From: Nicole M. Friedt, P.E., Development Review Engineer
AMAFCA

RE: DRB COMMENTS for PR-2019-002574

Lots 1 thru 9 Coors Pavilion (Chick-fil-A):

SI-2019-00191 – Site
Plan

SHEET TITLE  
**GRADING AND DRAINAGE PLAN**  
DWG EDITION ---  
Job No. : 65119594  
Store : 04107  
Date : 8/1/19  
Drawn By : LV  
Checked By : KW  
Sheet  
**3**

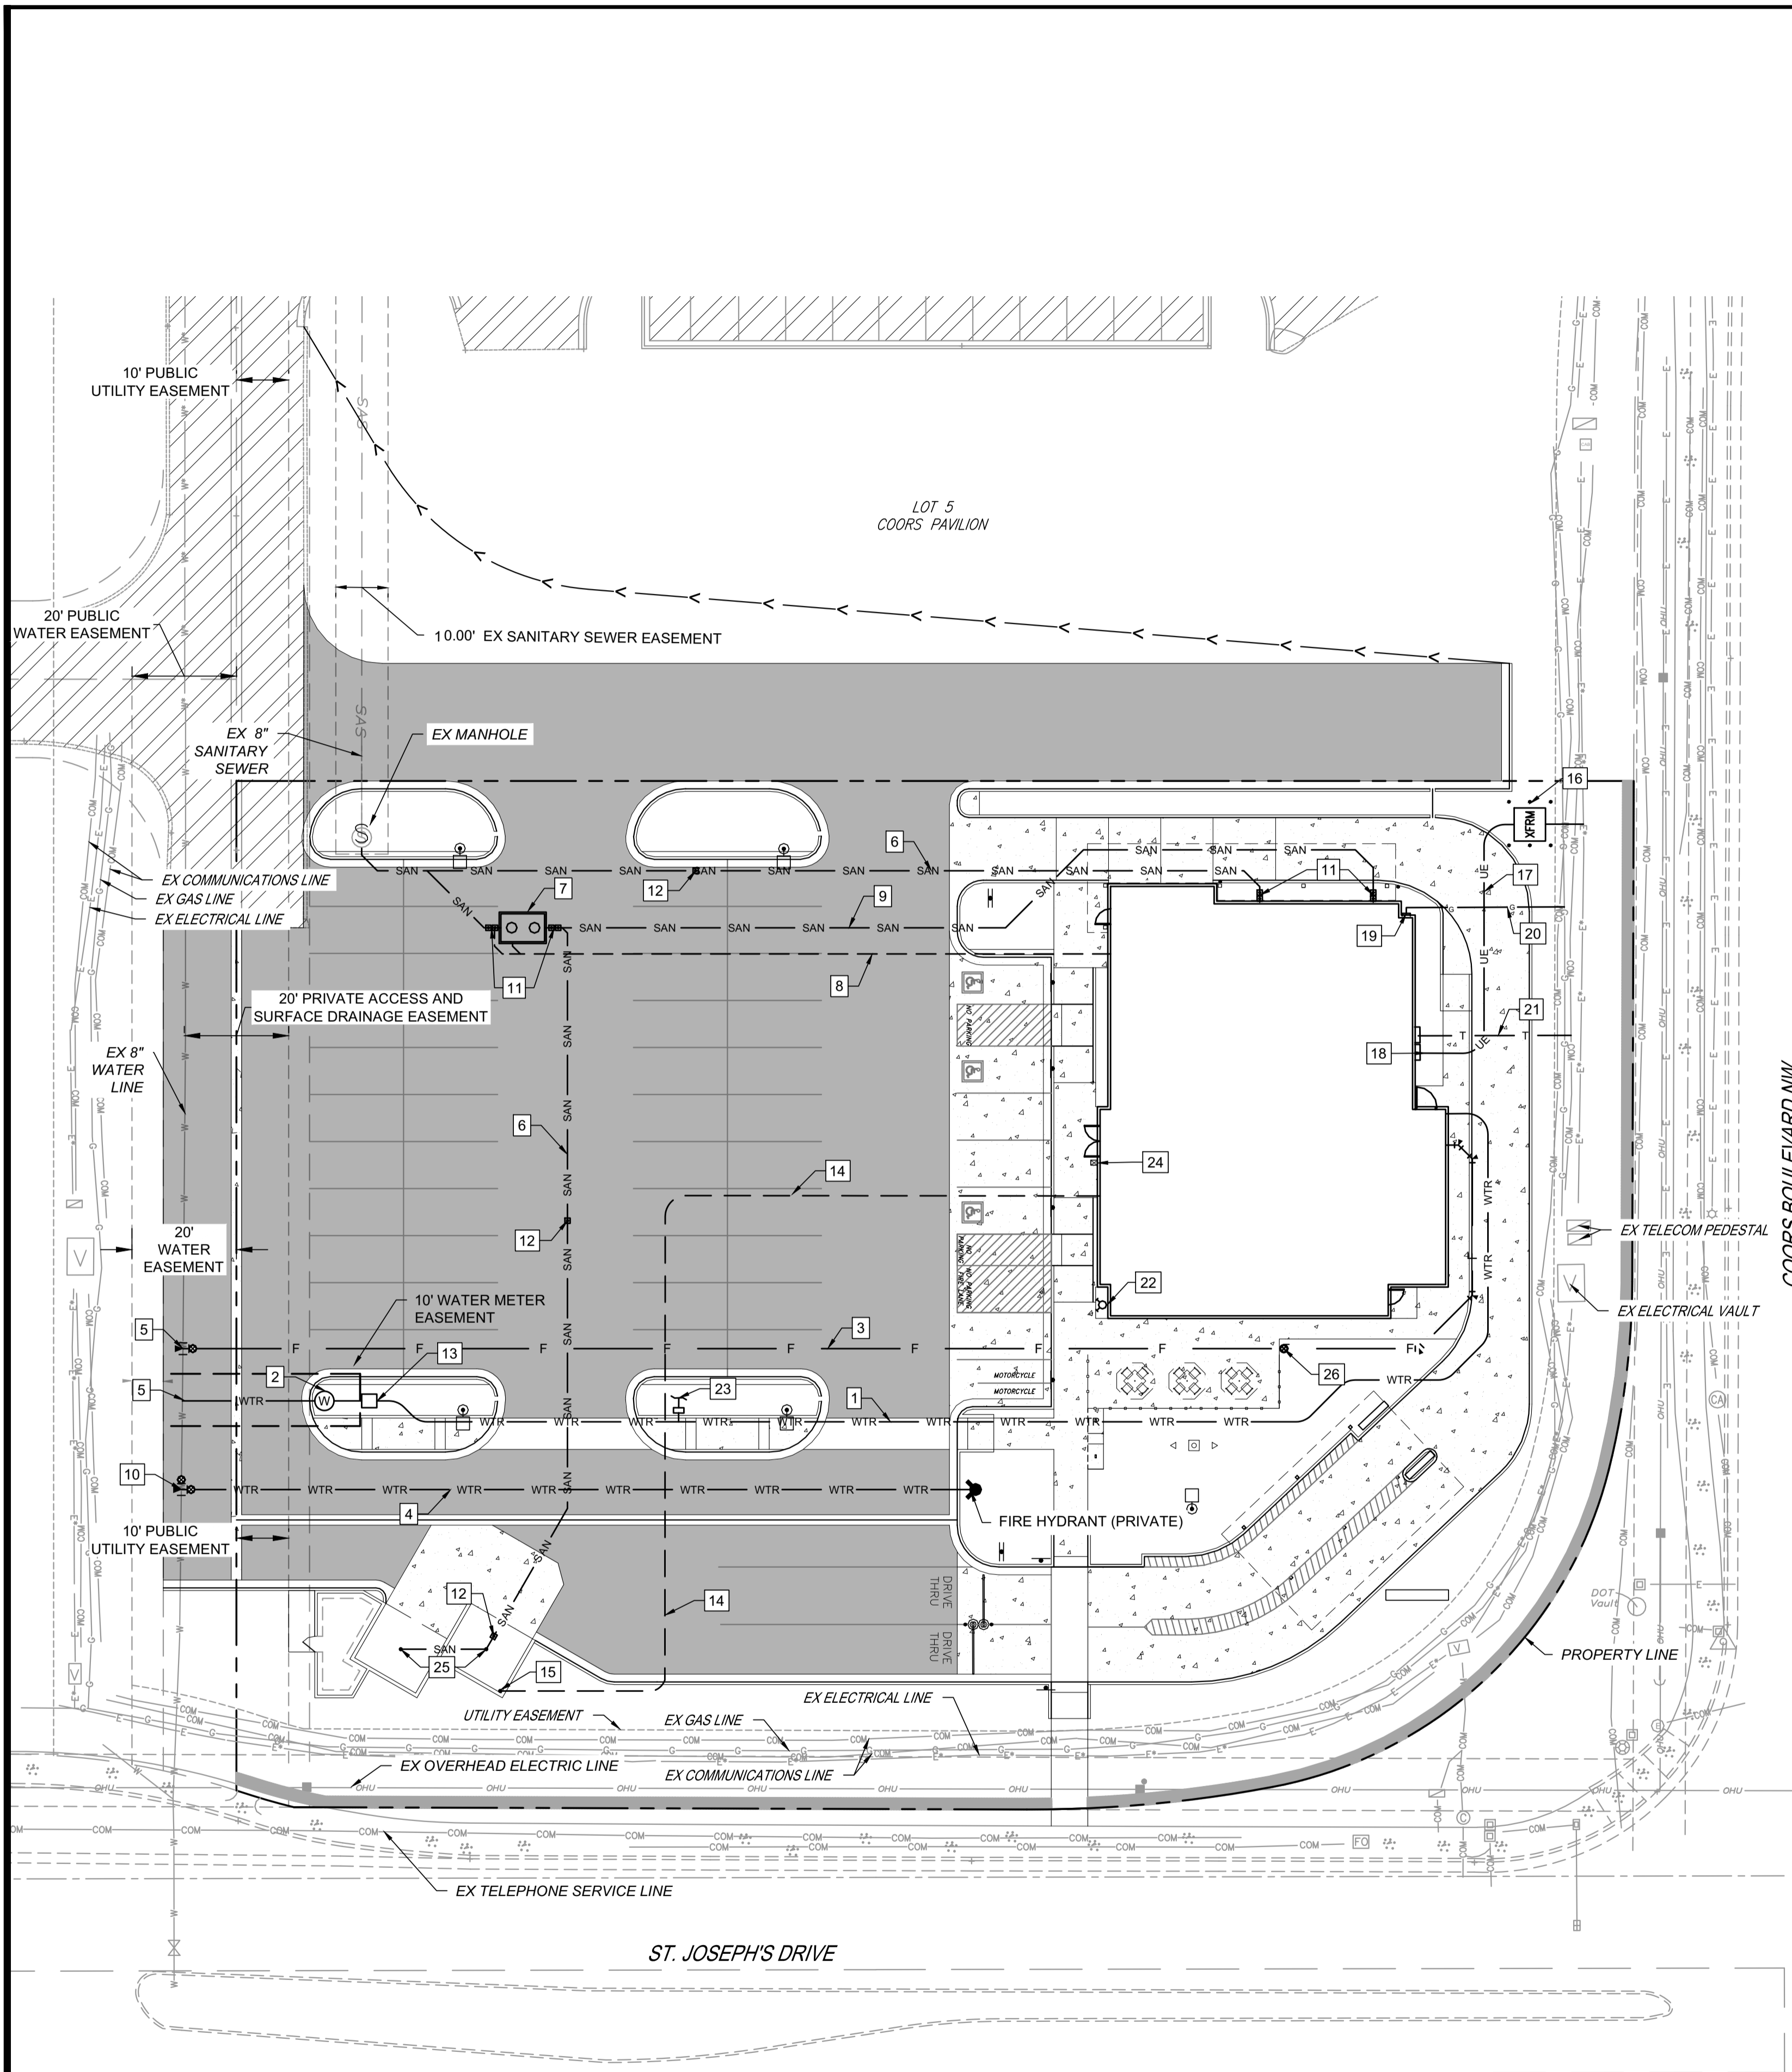
- Water off of B-1, particularly off the steeper sections, won't just immediately be sucked up by the infiltration trench. What is keeping the water from flowing over the top and past the infiltration trench?

Response: The infiltration trench will be handling very low flows, with the entire basin producing 0.5 cfs in the 100 year storm. This equates to 0.001 cfs per linear foot of the trench. In addition, the landscaping in this area will be rock mulch which results in a reduced velocity of the runoff. With these items considered, we believe that the trench will have no problem capturing the runoff of basin B-1.
